WEST SUSSEX COUNTY COUNCIL CONSULTATION

TO:	Arun District Council FAO: Amber Willard
FROM:	WSCC – Highway Authority
DATE:	18 July 2025
LOCATION:	Land rear of Waterbury House Ford Road Ford BN18 0BH
SUBJECT:	F/21/24/PL Erection of 4 No supported living units (C3(b)), office block, car parking and associated works. This application is a Departure from the Development Plan, affects the setting of a listed building and is in CIL Zone 3 and is CIL Liable as new dwellings.
DATE OF SITE VISIT:	11 July 2025
RECOMMENDATION:	More Information Required

PROJECT	WATERBURY GARDENS - FORD
DESIGNER	ASH
PROPOSED SITE PLAN	
DATE	14/02/24
REF. NO.	00072404
DRAWN/CHANGED BY	SP9
DESIGNER'S SIGNATURE	
REVISION

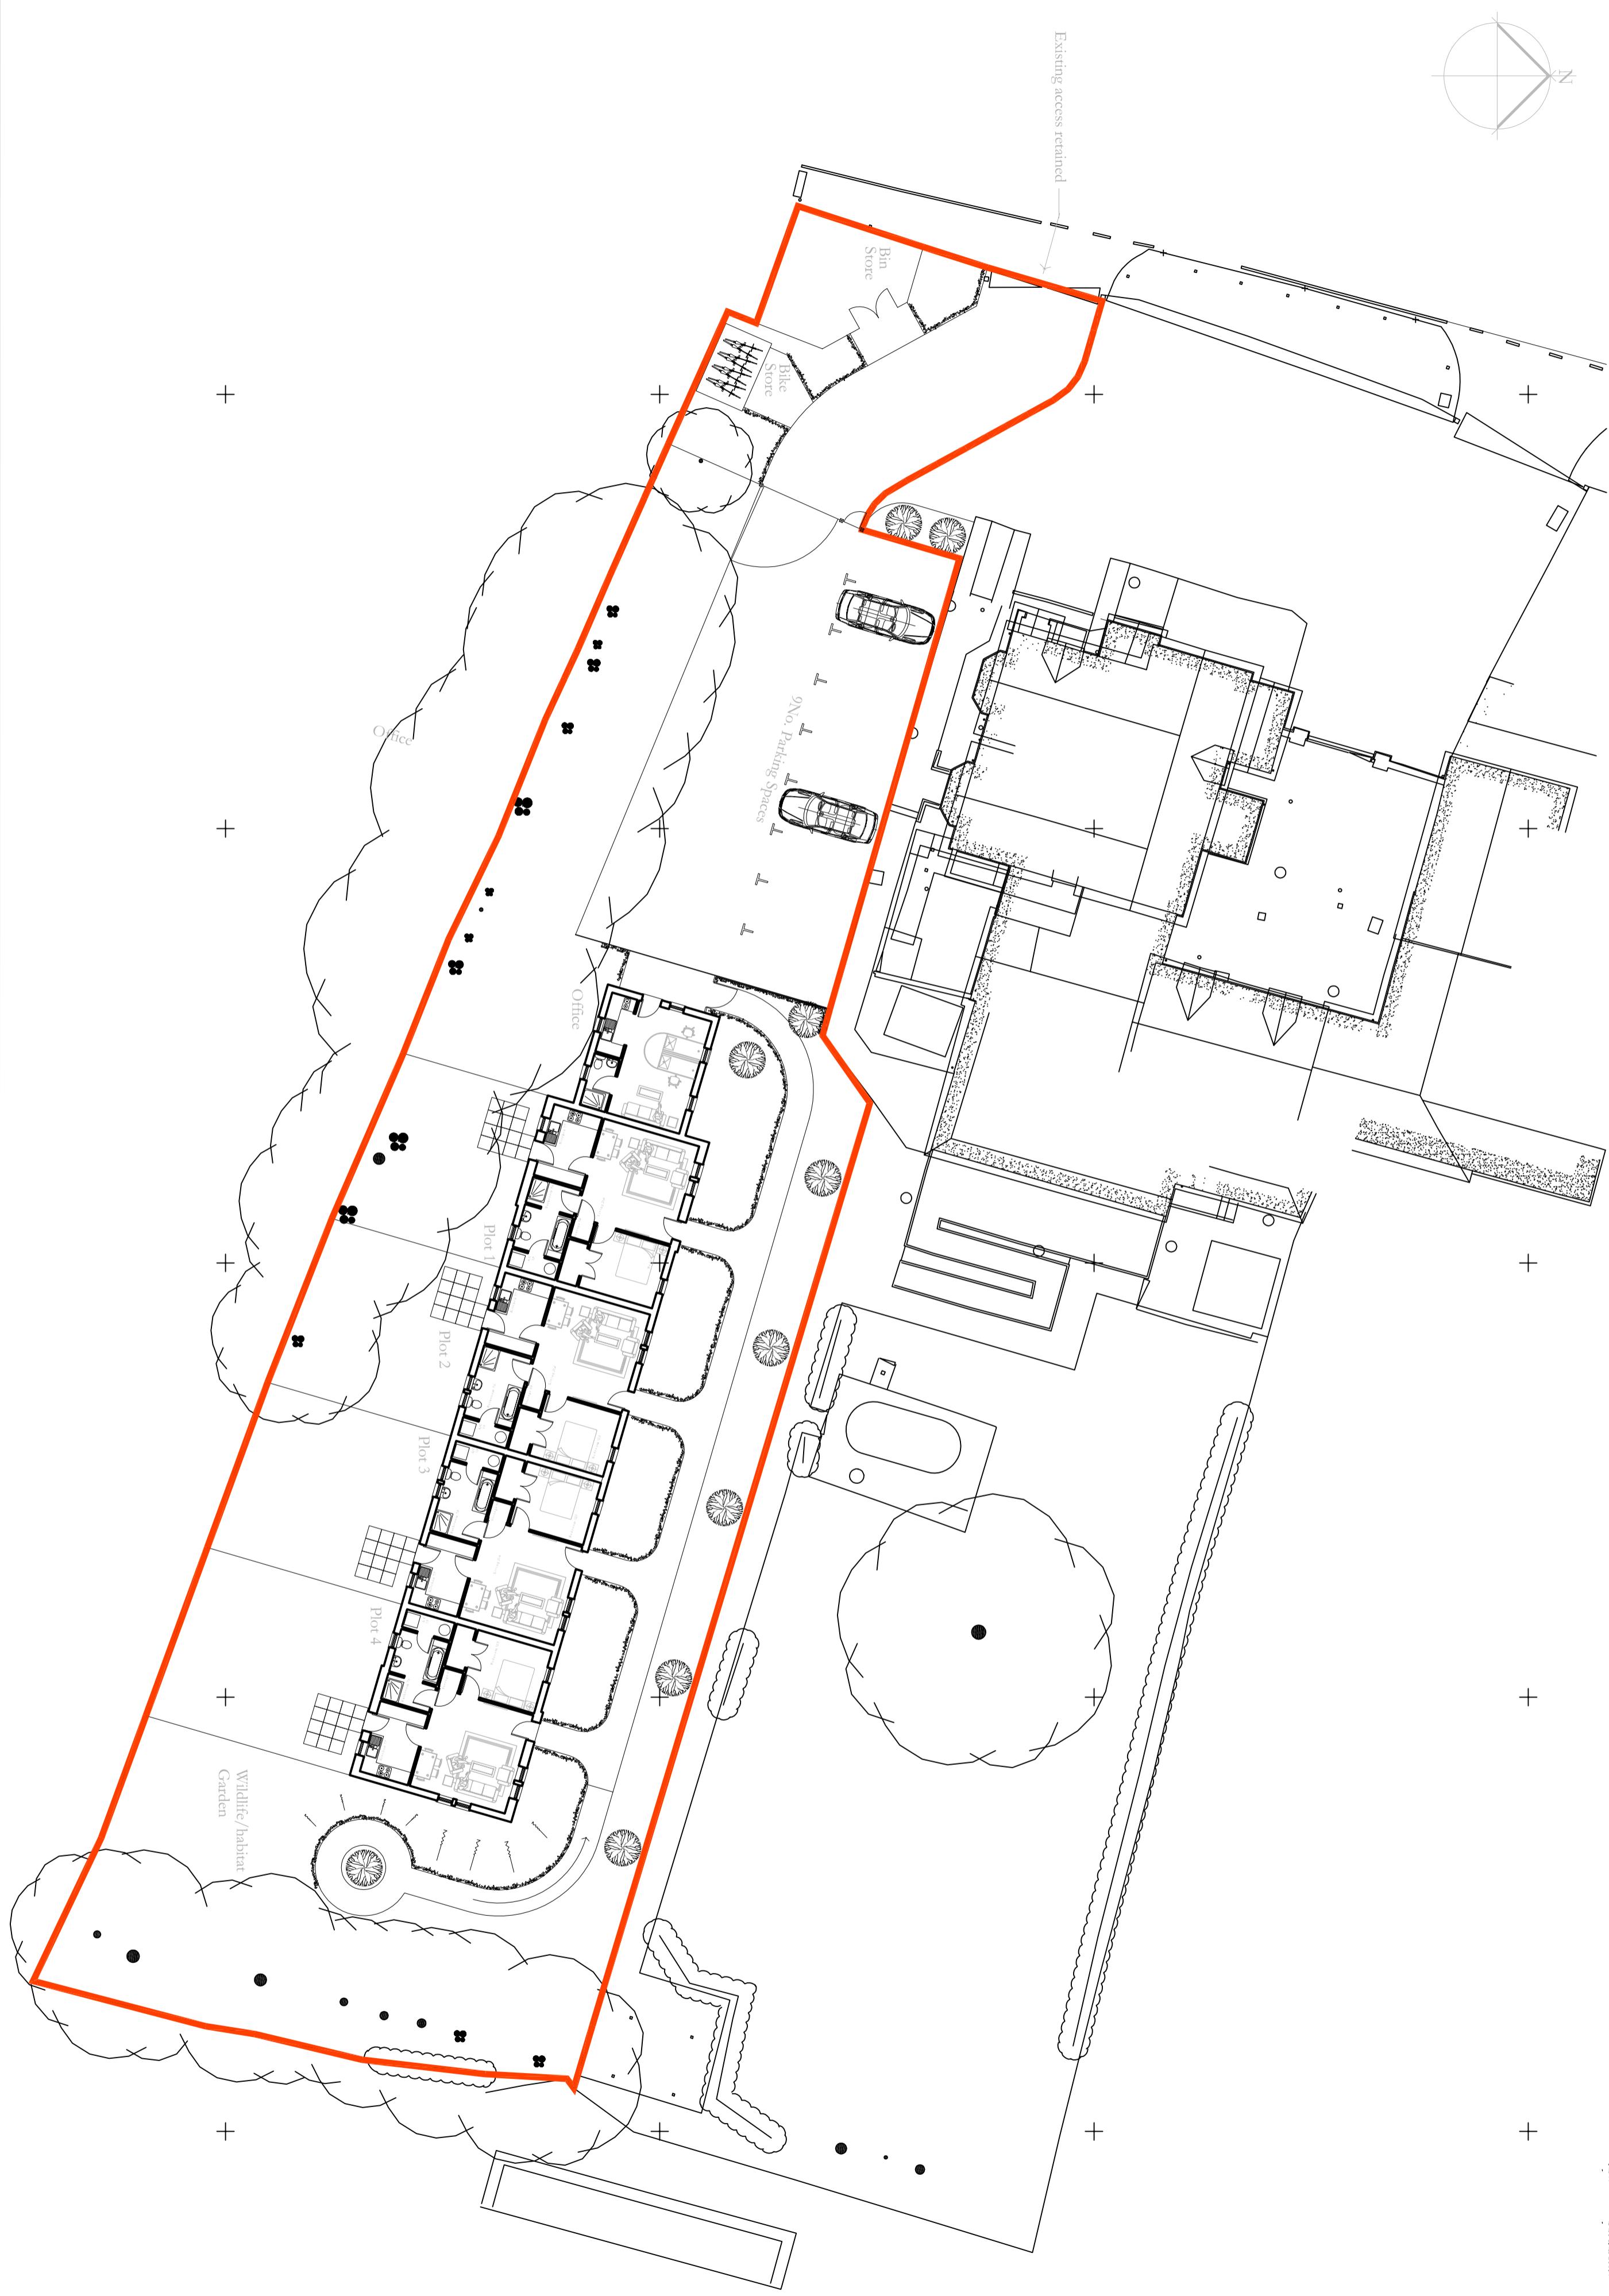
The proposed site plan implies that access to the site would be from the existing southern access to Ford Road. The actual notation on the plans says "*Existing access to be retained*". Access would then continue south of the existing building and onwards to a car parking area for nine vehicles. The existing bin store is shown amended to accommodate the access and some cycle parking is also shown. However, it is not

known whether both are intended for use by the new scheme or whether it would have its own. Specifically for the cycle parking, it is recommended that if possible, that each unit has its own cycle parking store allocated to it.

Given the close proximity of the southern access to the site to the adjacent railway crossing, the Highway Authority recommends that this access be permanently closed to traffic entering and/or leaving the site, as additional vehicles generated by the proposal (particularly those turning right into the site) would be attempting to make that manoeuvre very close to the crossing which could cause obstruction on Ford Road and blocking back over the railway crossing. In addition, it is recommended that the existing crossover and 'KEEP CLEAR' markings on Ford Road should also be removed. All traffic to and from the site would then have to use the northern access, further away from the crossing.

An amended plan should be provided showing the existing southern access to Ford Road permanently closed off (also showing how it would be closed off), plus crossover reinstated and 'KEEP CLEAR' road markings removed, too.
